**WEST SUSSEX COUNTY COUNCIL
STRATEGIC PLANNING CONSULTATION**

SUBJECT: BE/98/12/PO - App to modify Planning Obligation dated 04/08/2006 under BE/45/04 & subsequent Deed of Variation dated 10/03/2010 in respect of flood compensation area, healthcare, open space, sports facilities and highway upgrade contribution.

Site 6, Land North of Bersted, Chichester Road, Bersted, Bognor Regis, West Sussex

BLOOD COMPENSATION AREA

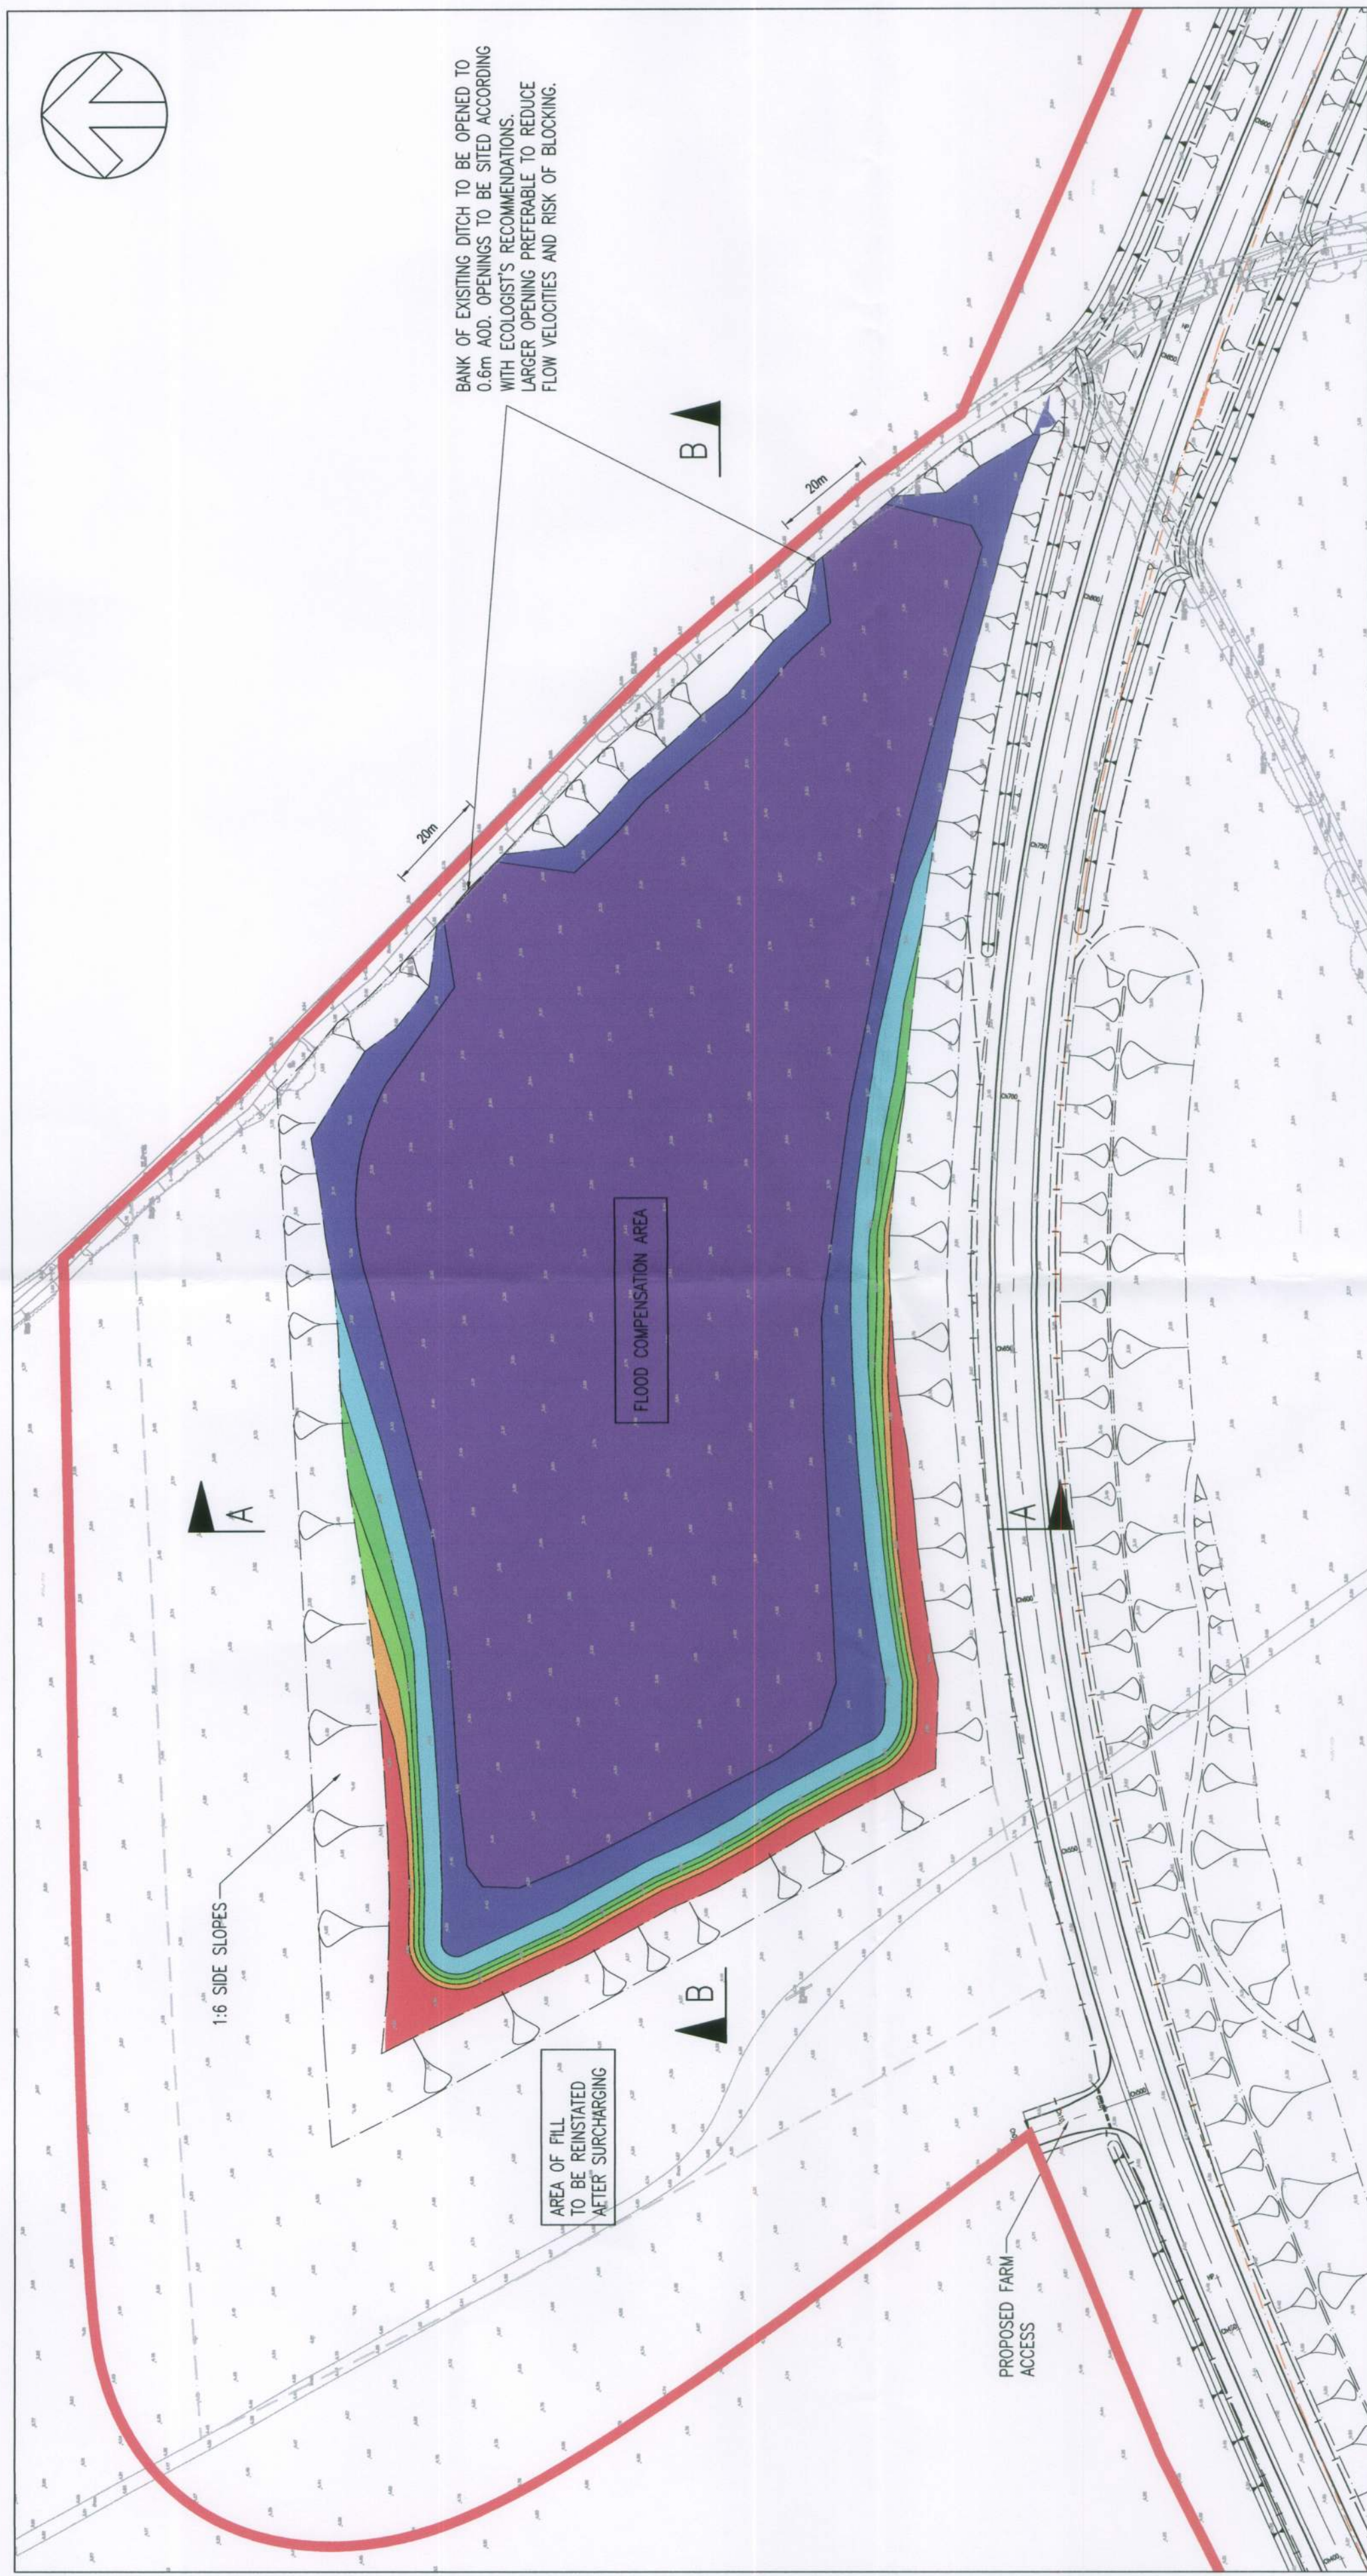
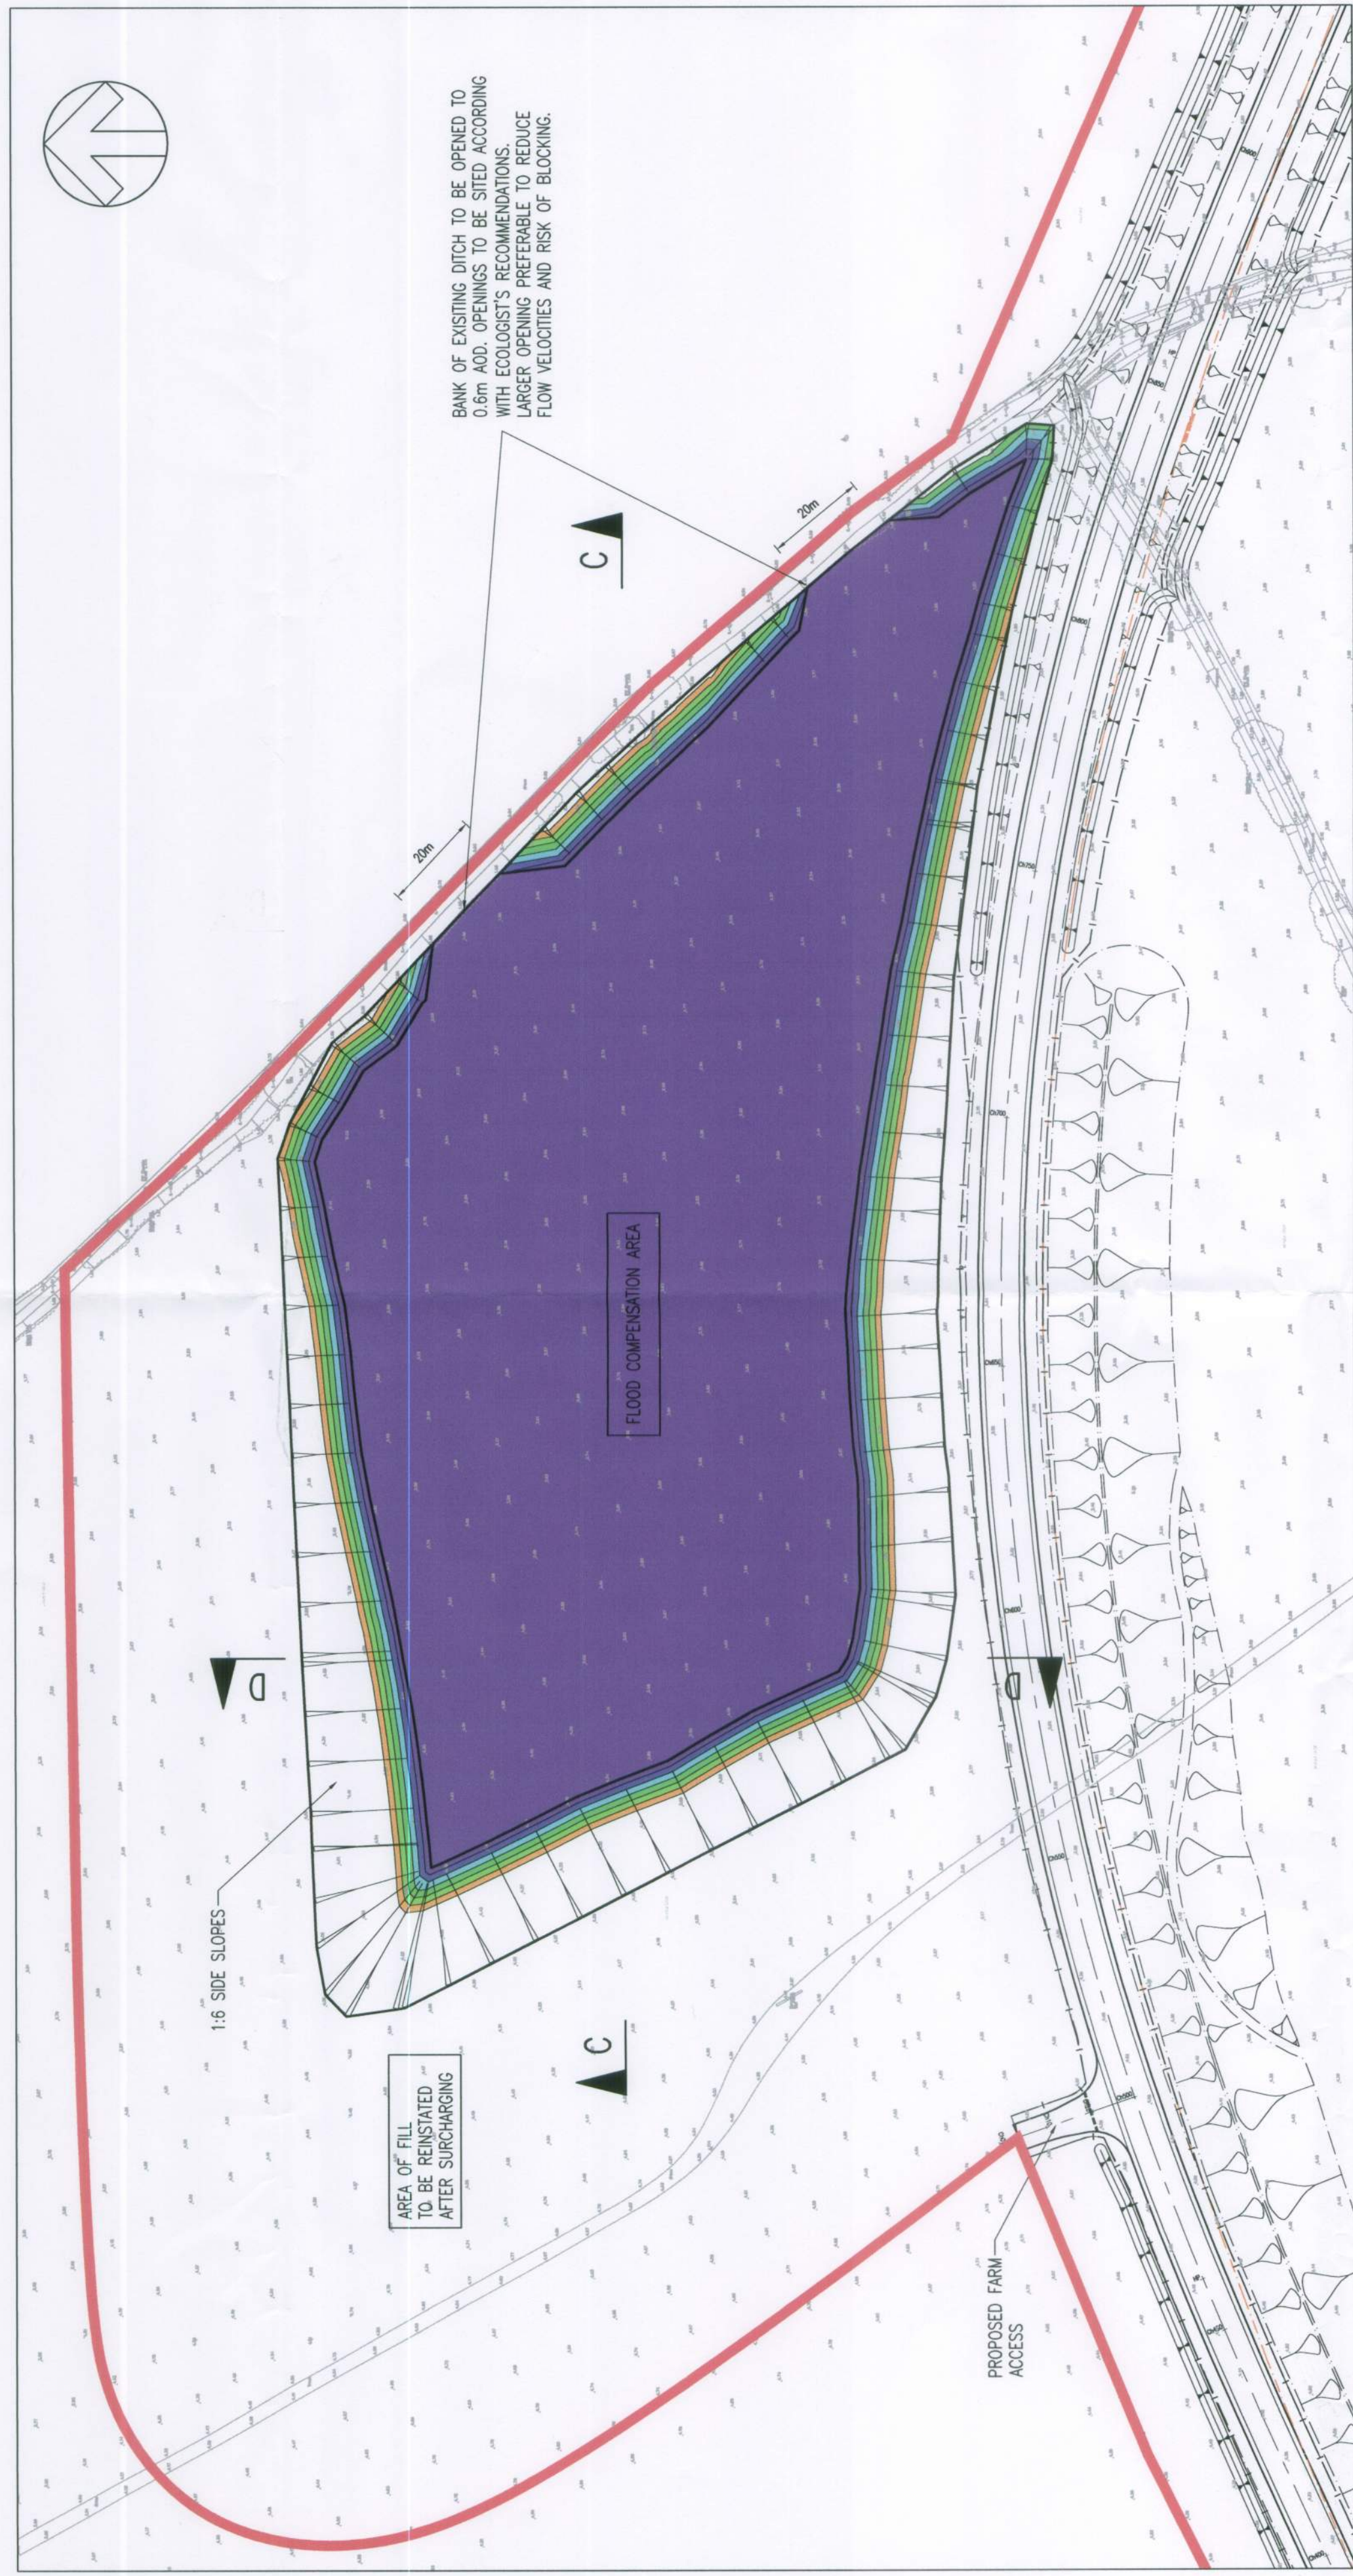
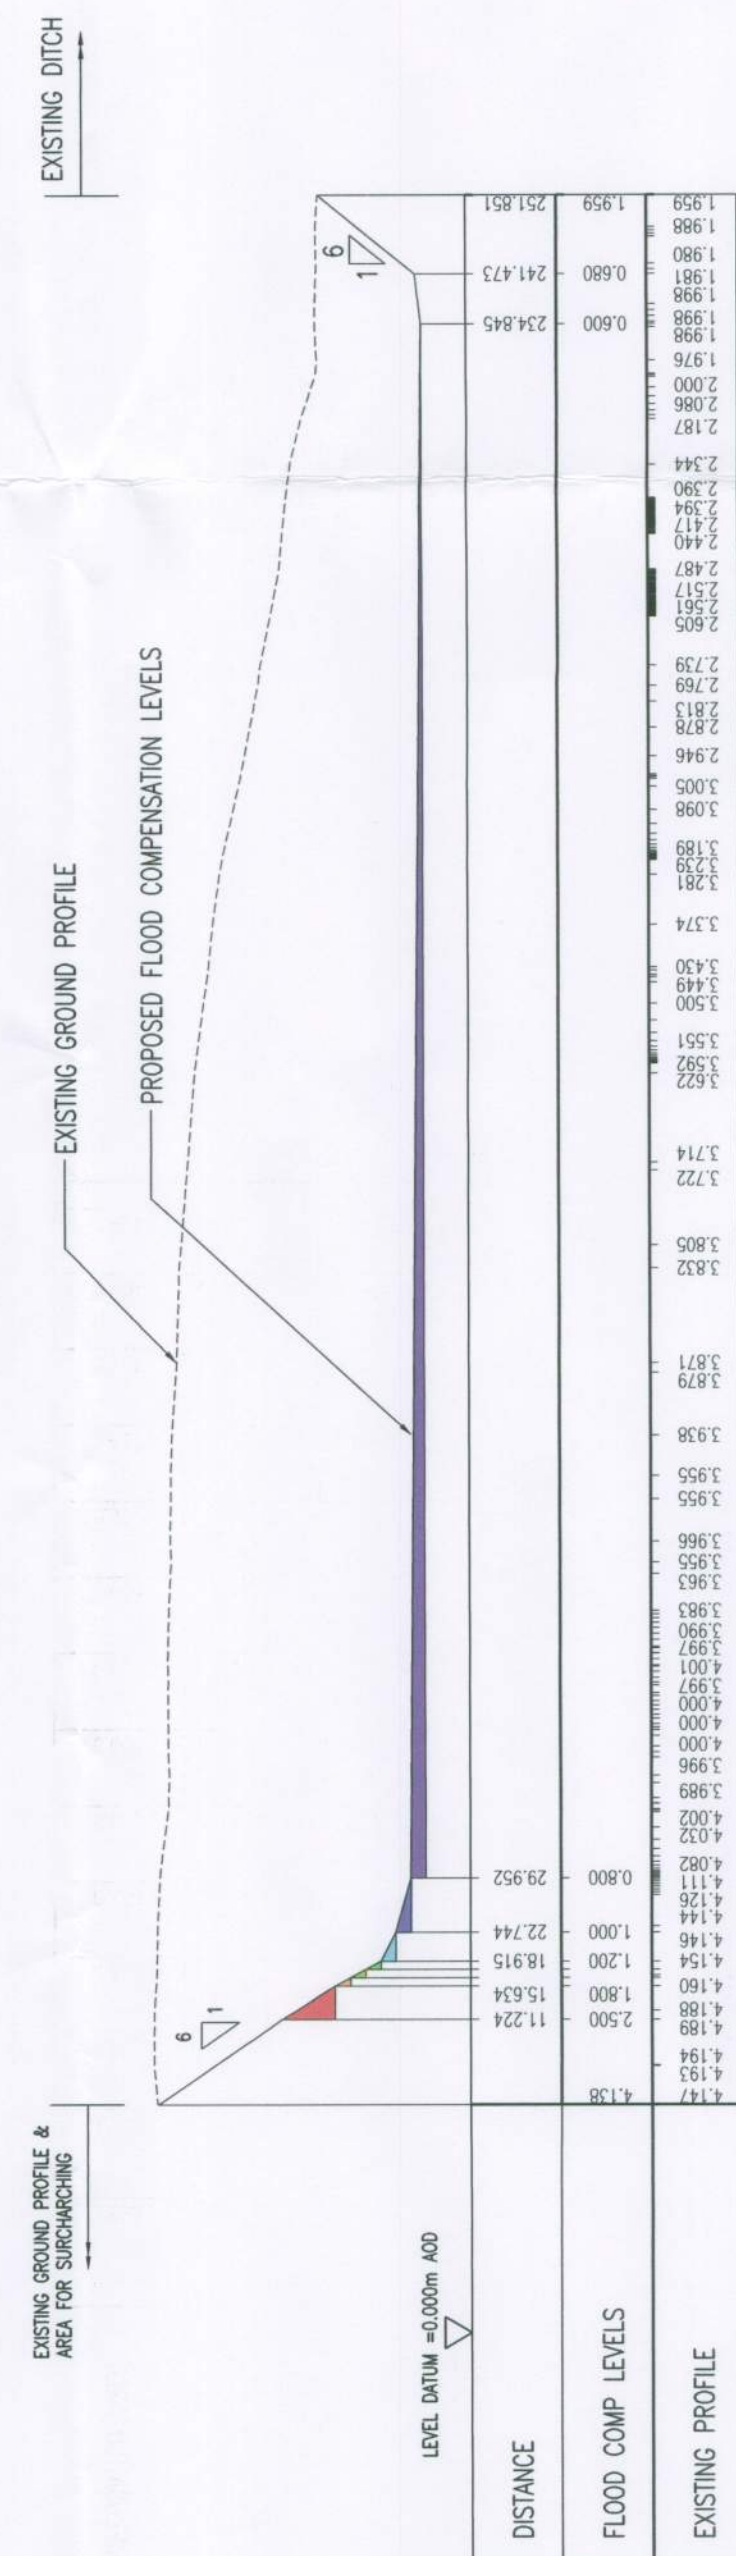
Flood Compensation Area - Revised trigger proposed for the construction of the FCA increased to 350 dwellings. This is acceptable technically, providing the FCA is completed before the road is completed and the Environment Agency have no objections.
